Subject: Request for advice on EIS- Mixed use with infill affordable housing – 3-5 Help Street, Chatswood (SSD-76555711) (Willoughby City)

CPHR response on the EIS - Mixed use with infill affordable housing – 3-5 Help Street, Chatswood (SSD-76555711)

Title
EROSION AND SEDIMENT
CONTROL DETAILS

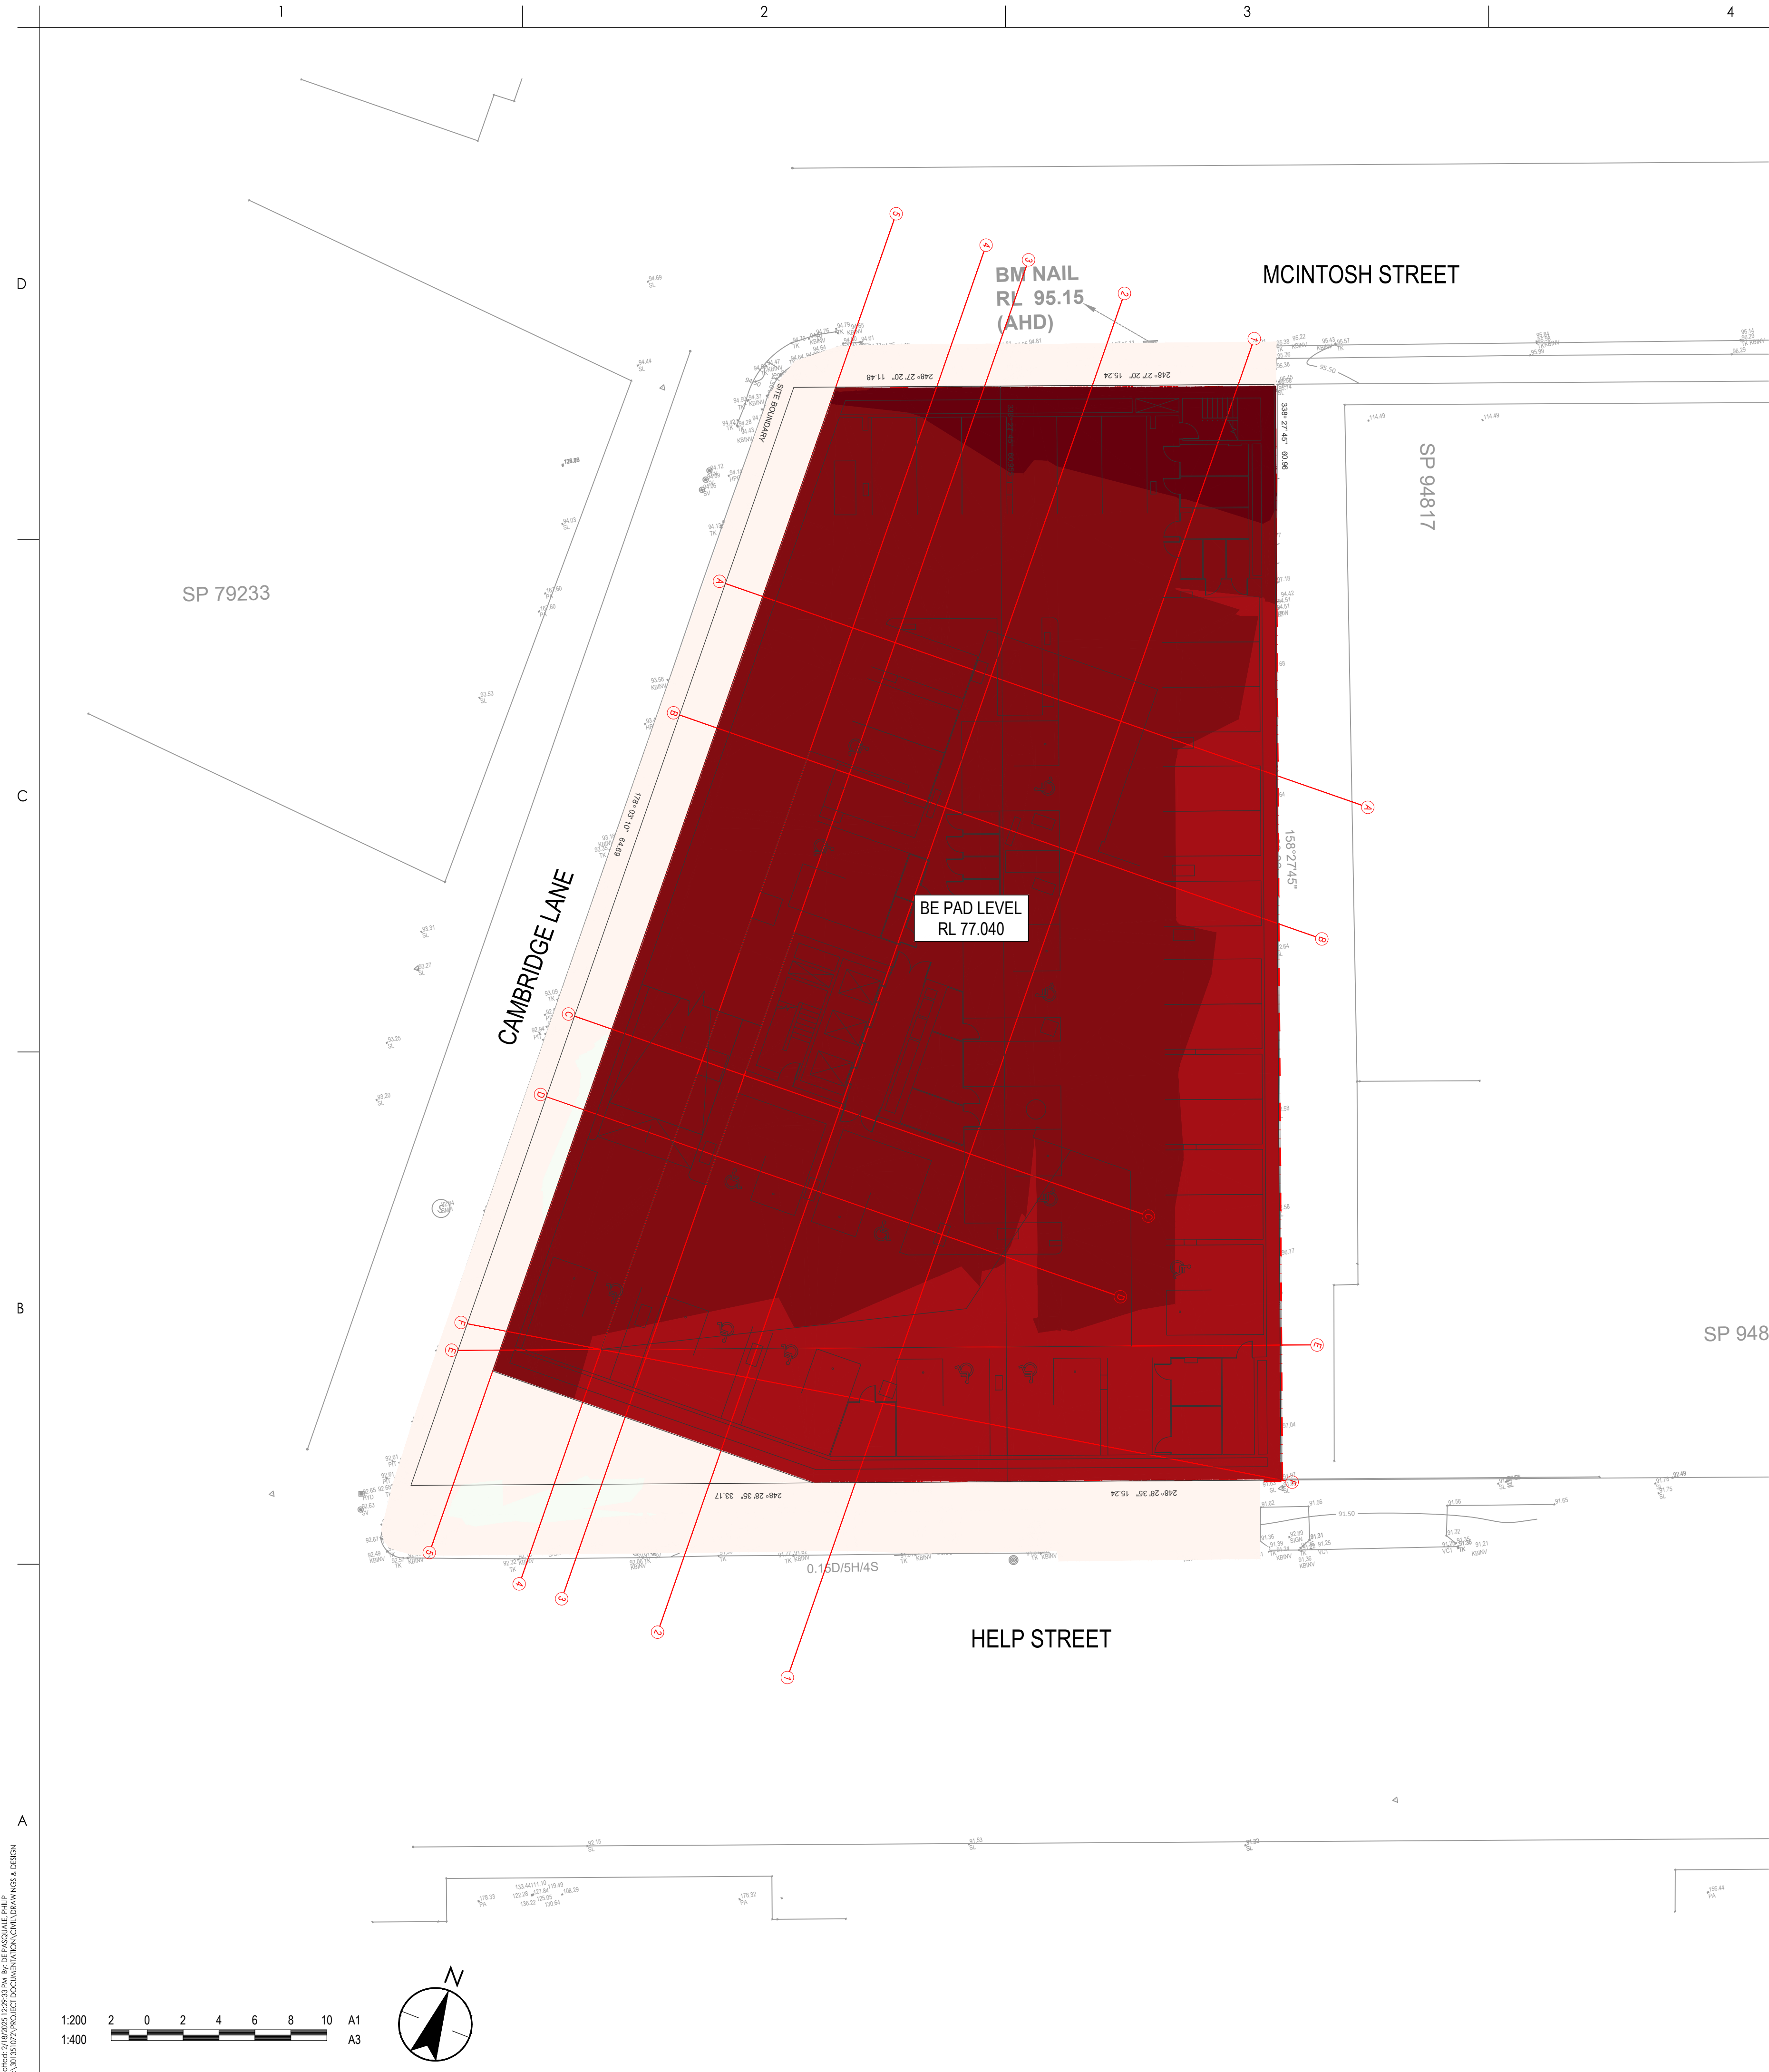
<i>Extent and Timing</i>	Detailed design
7.	Erosion and sedimentation controls are not adequate for the degree of site disturbance.	The provided erosion and sediment control plan is suitable for site clearing only. The site will generate significant spoil (34,500 cubic metres) during basement excavation which will require a detailed staging plan for soil and water management during construction. Recommendation action: Prepare detailed staging plans for management of soil and water during each stage of construction.
	<i>Extent and Timing</i>	Detailed design
